Application Ref: 21/00290/ADV

<p><b>UPRN:</b> 000120036115 _____ (If <b>NO</b> UPRN – Admin to contact Technician)</p> <p><b>Site Address:</b> <i>(Leave blank if no UPRN)</i></p> <p>Land South West of Tesco Superstore Dalkeith</p>	<p><b>Description of Proposal:</b></p> <p>Display of illuminated and non-illuminated signage including fascia, totem and free standing signs</p>
---	--

**APPLICATION INCOMPLETE**

drawing Proposed Site Plan original size A1

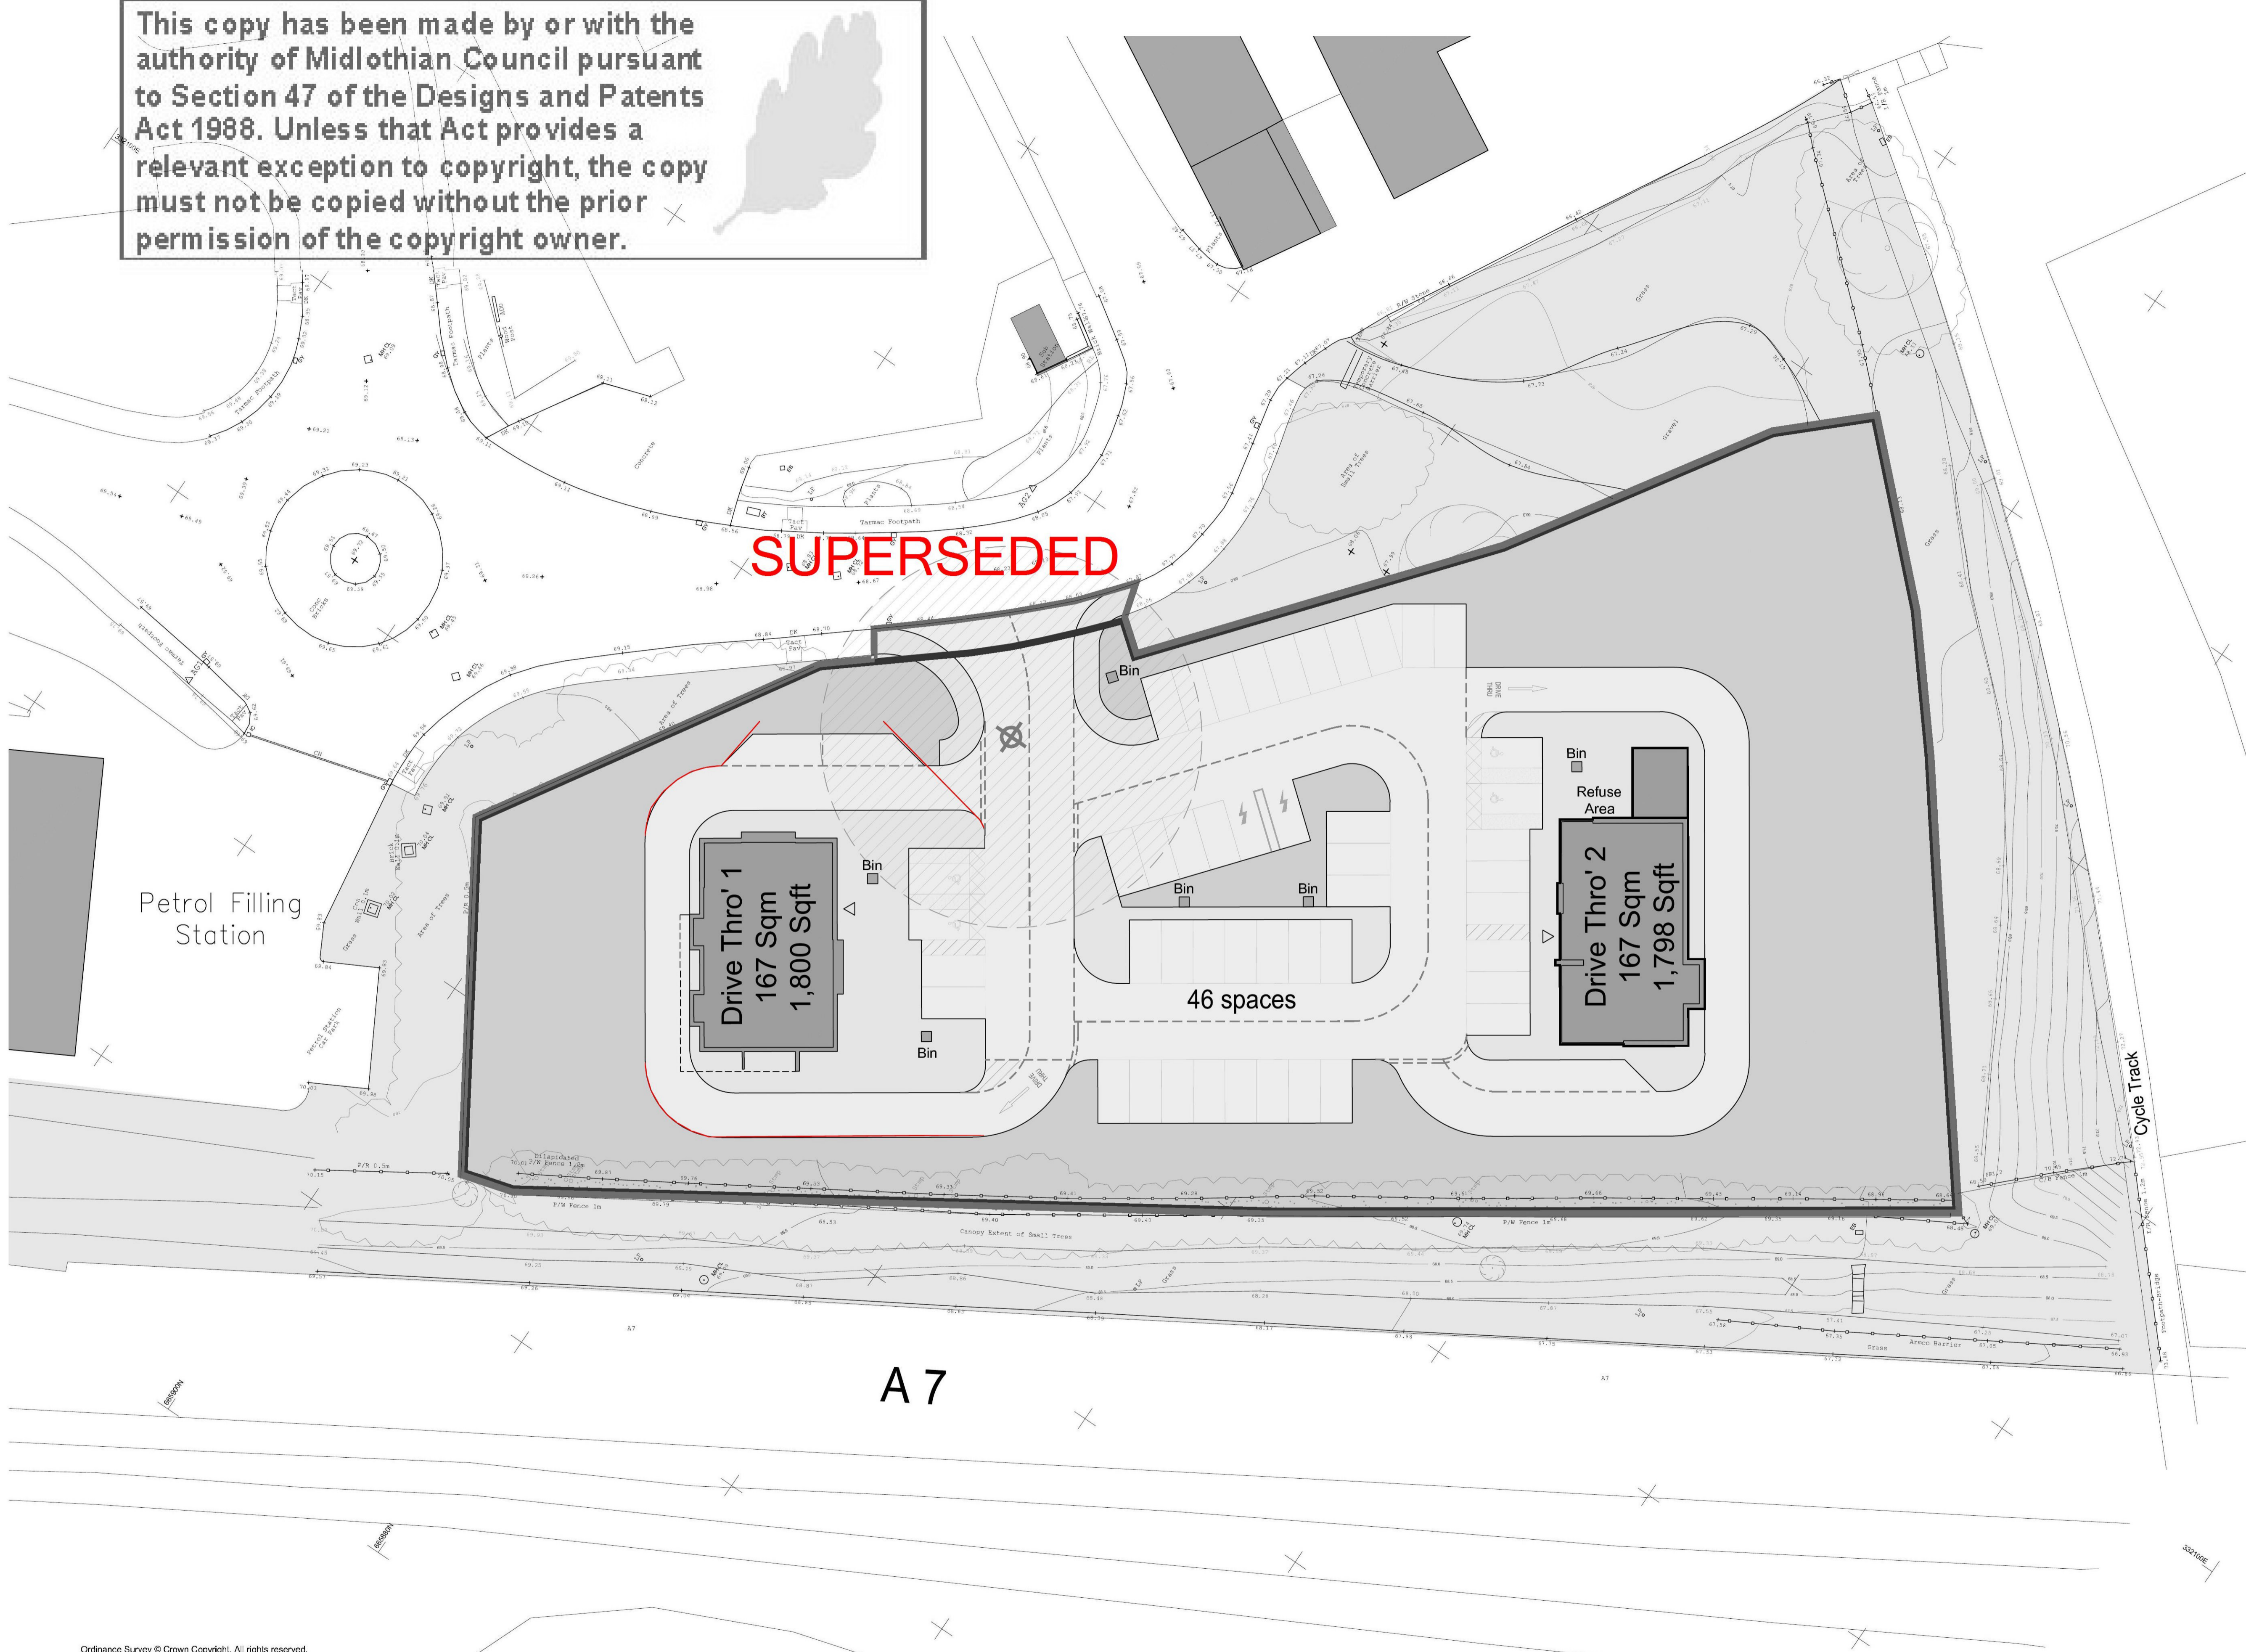
Please identify the application site, the full extent of the planning unit boundary with all proposed advertisements which require consent located within the red line boundary.

02-3 PROPOSED ELEVATIONS

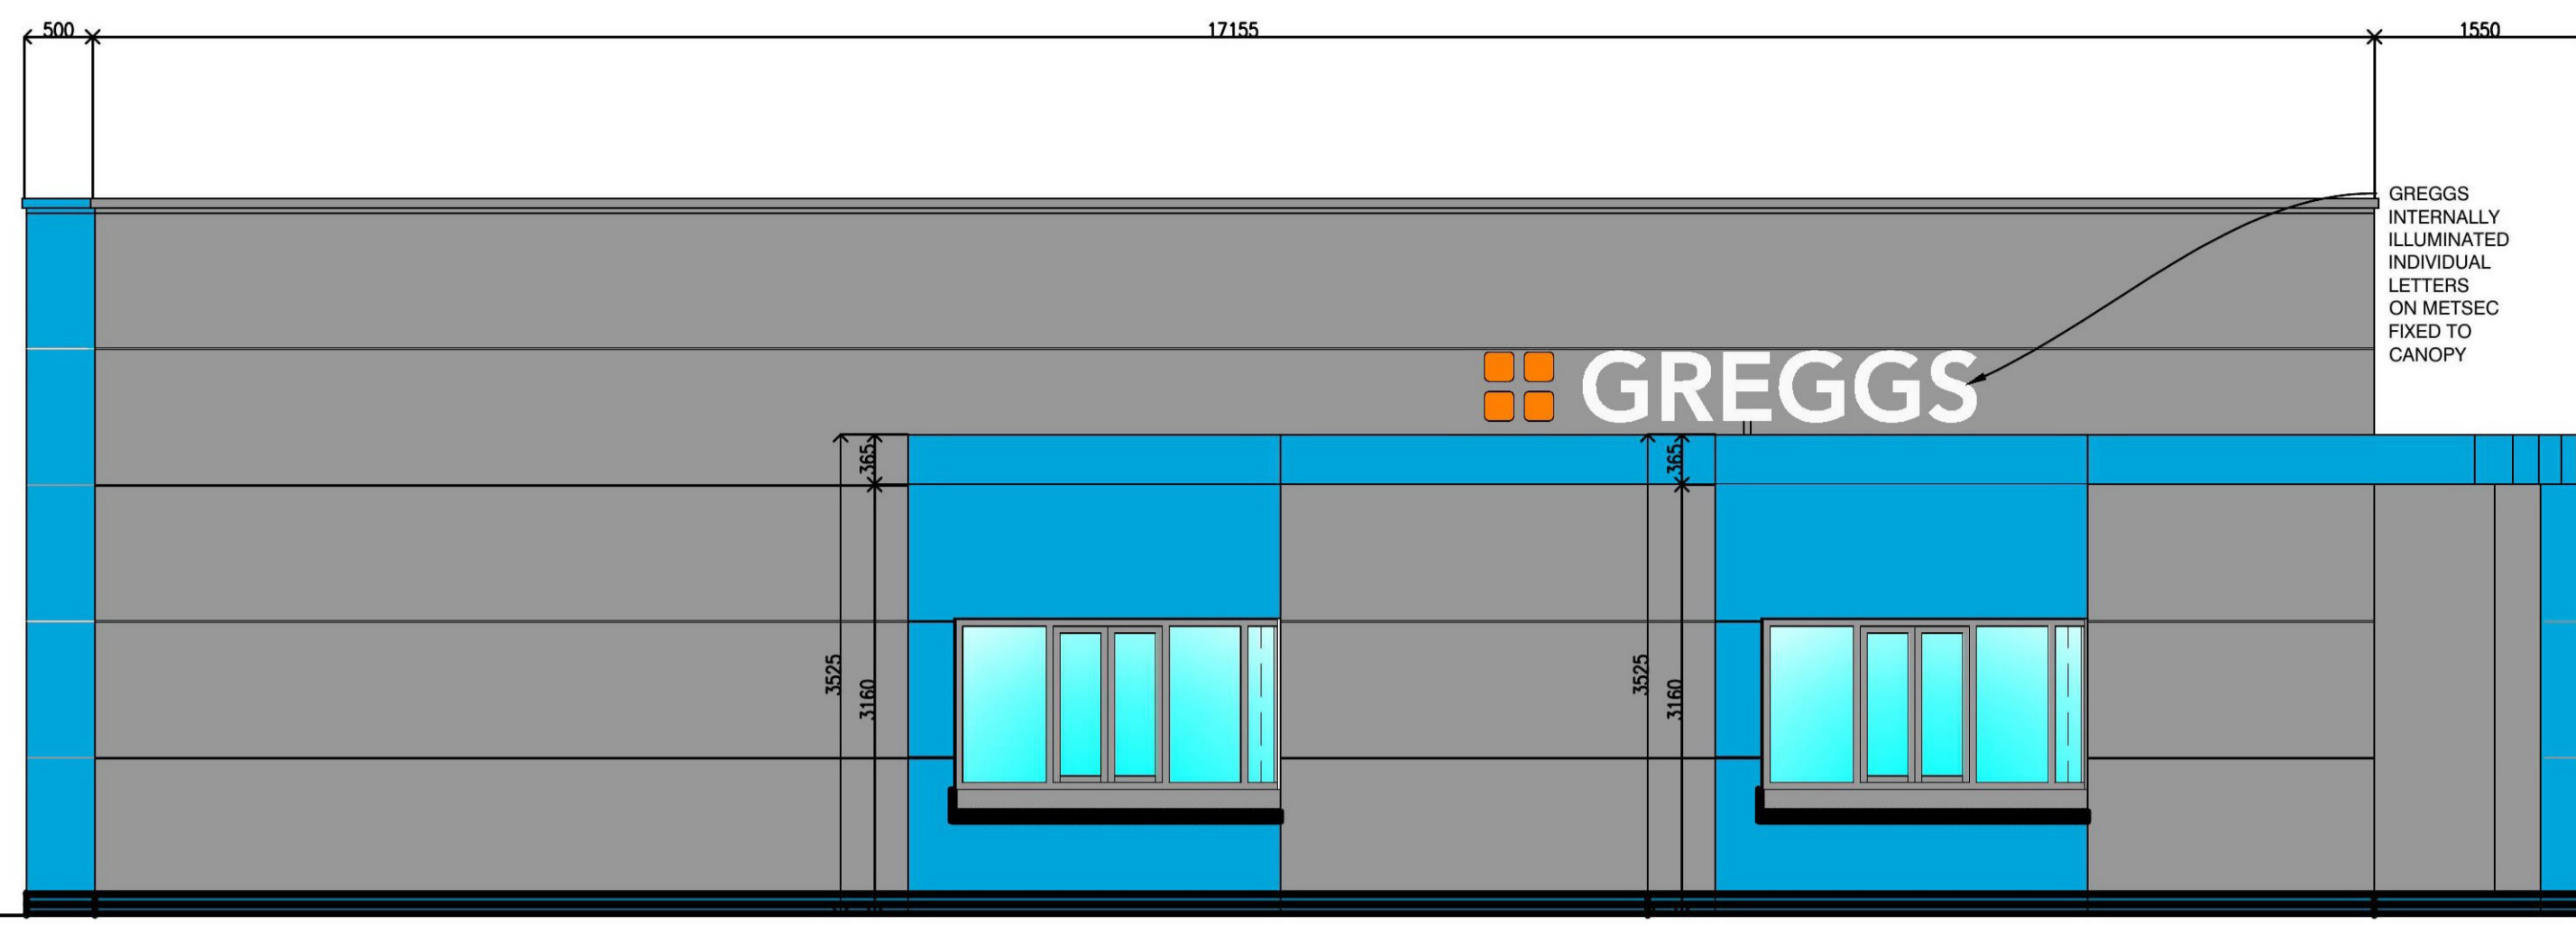
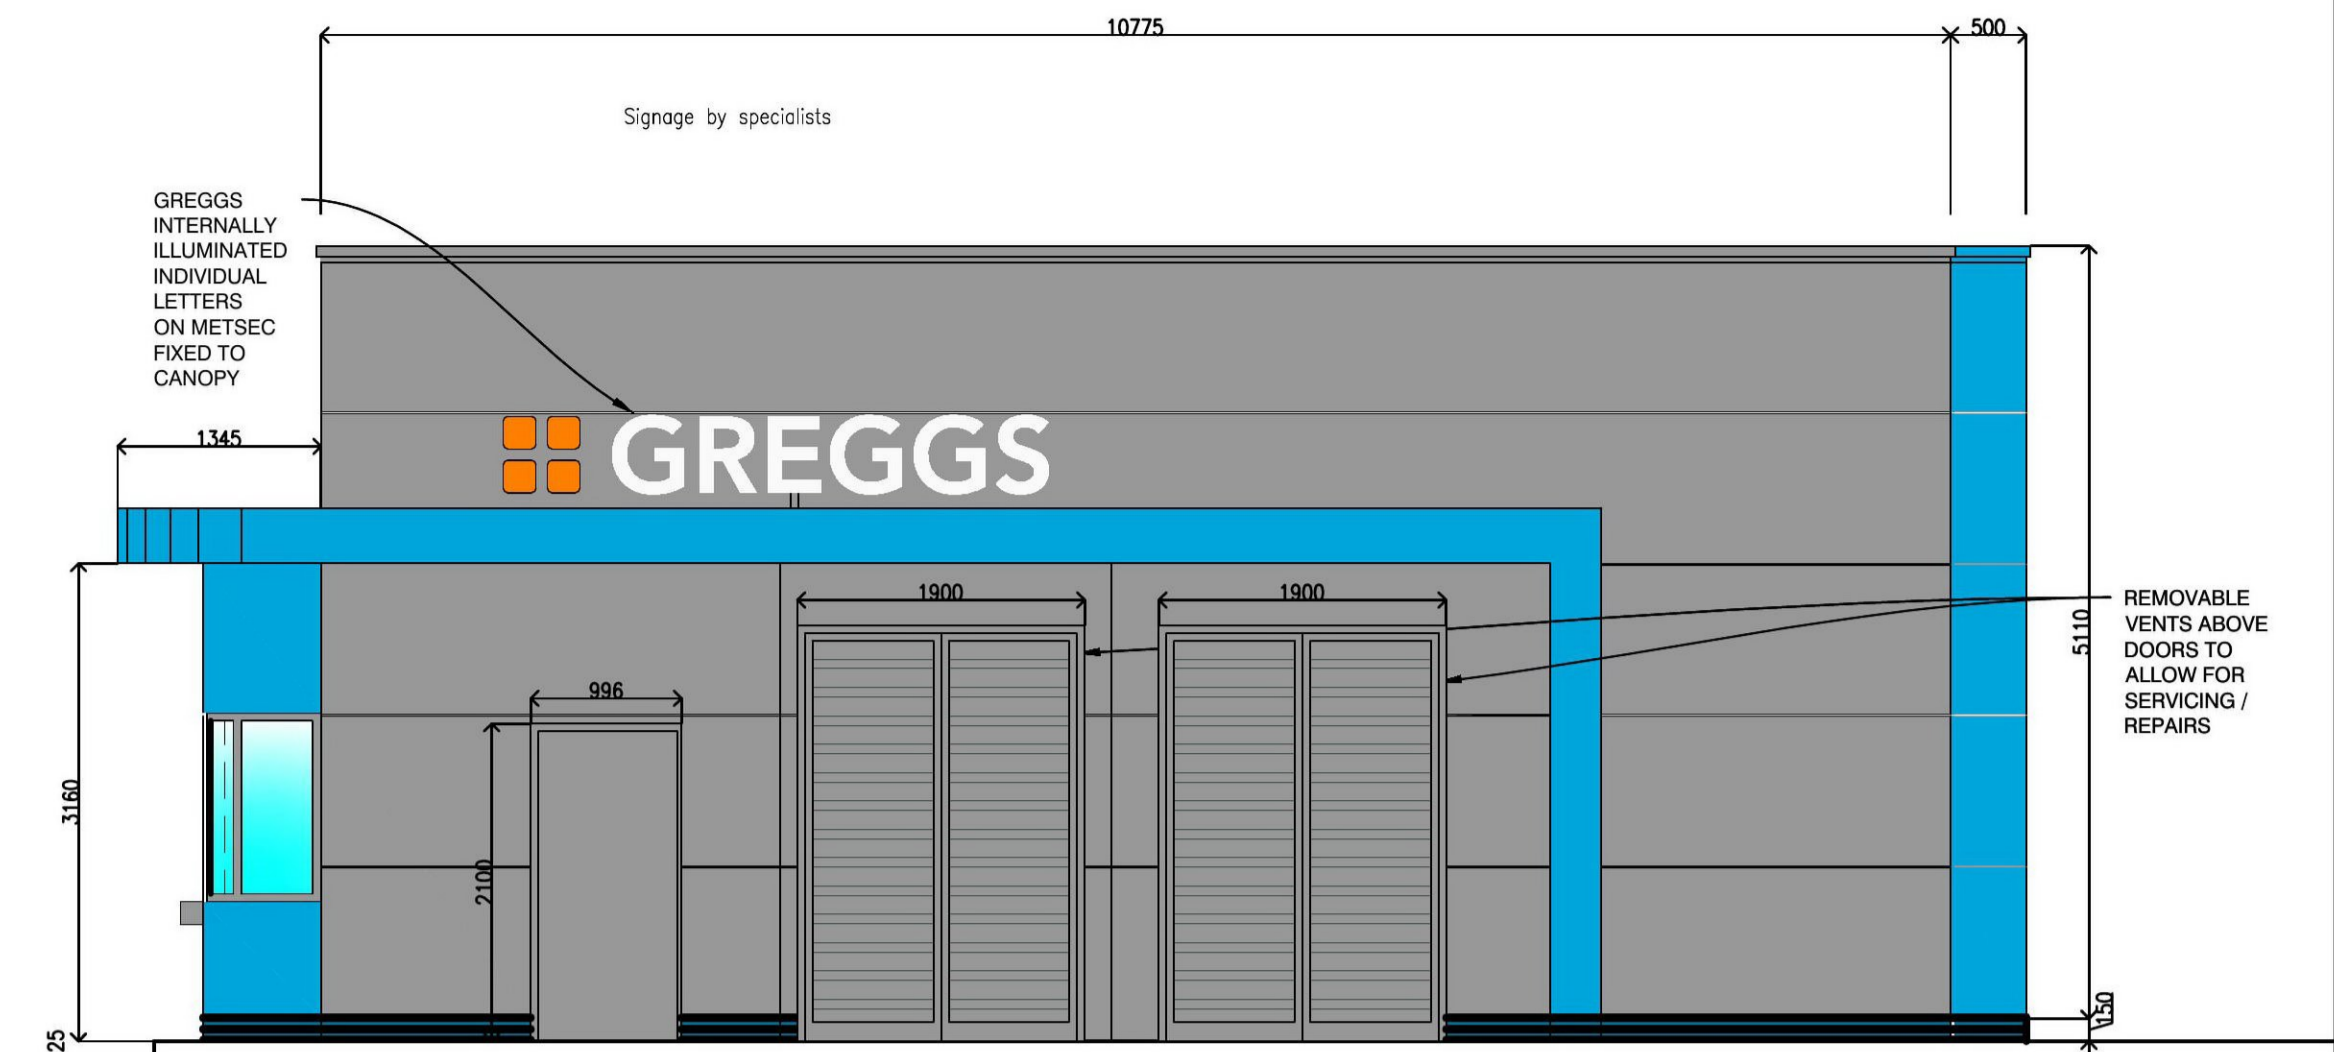
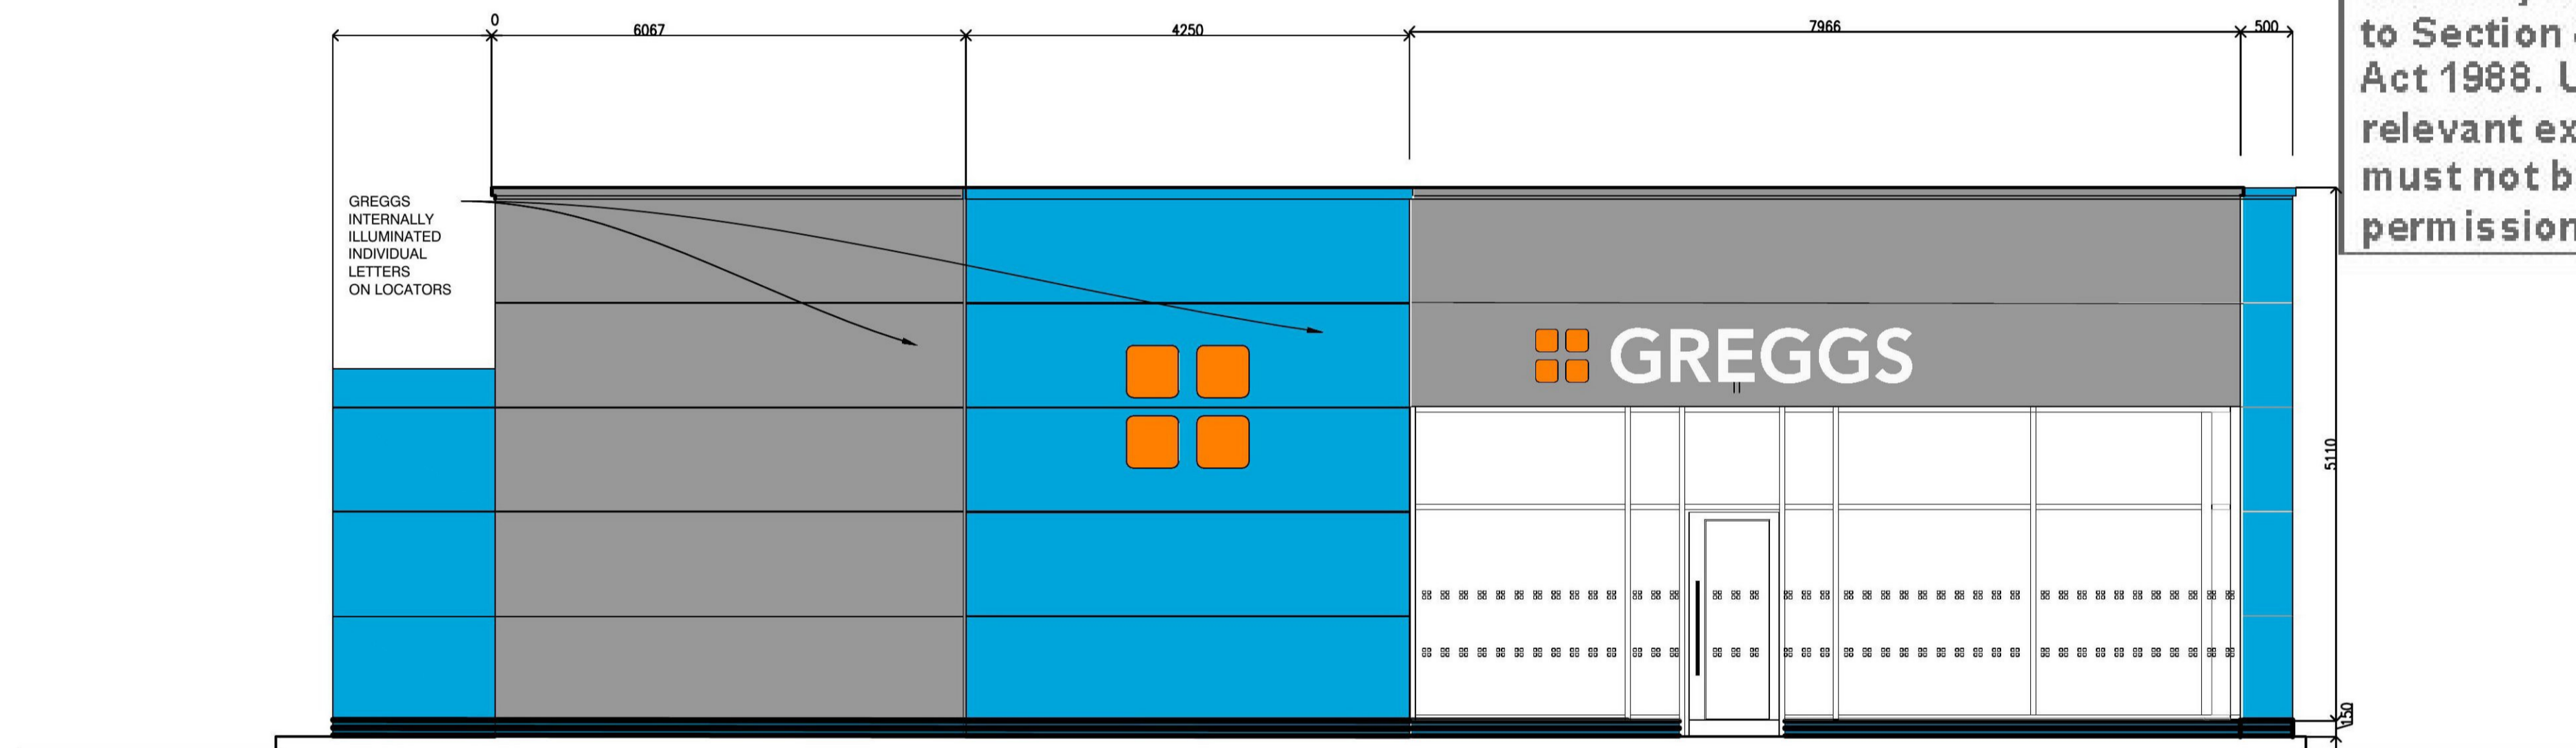
On drawing no. RNTH/S5554/02-3 the proposed totem sign is not labelled as sign 8.

On drawing no. RNTH/S5554/02-3 there is no indication of whether the signs are illuminated or non-illuminated.
